From: Ian Brewster**Sent:** 01 August 2012 16:31**To:** Janice Chapman**Subject:** BR/187/12/TC Hotham Park House High Street Bognor Regis PO21 1HW

I have inspected the Evergreen Oak tree with Mr Ian Harris yesterday and confirm that the work is necessary to avert a health and safety risk where it is evident that dead wood and basal bark disease is apparent.

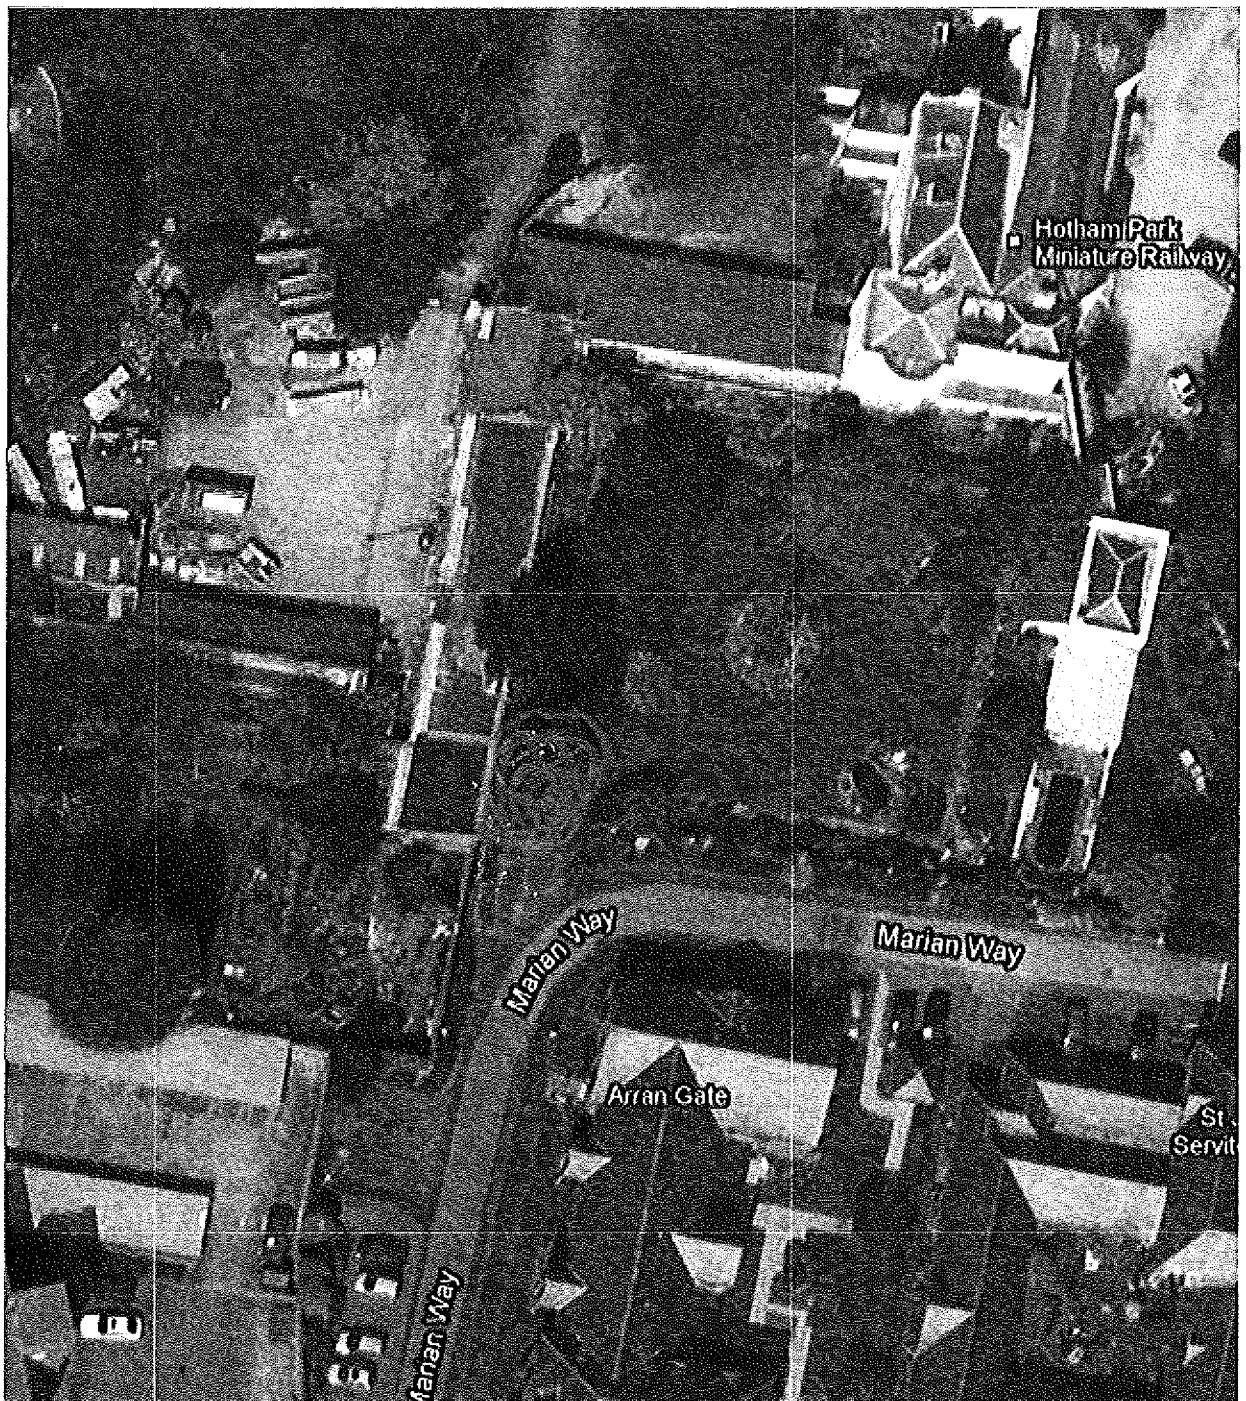
Mr Harris showed me further work which appears to be acceptable. However he would also be required to similarly identify the work and send it to us with details and a plan with the tree surgeons recommended specifications.
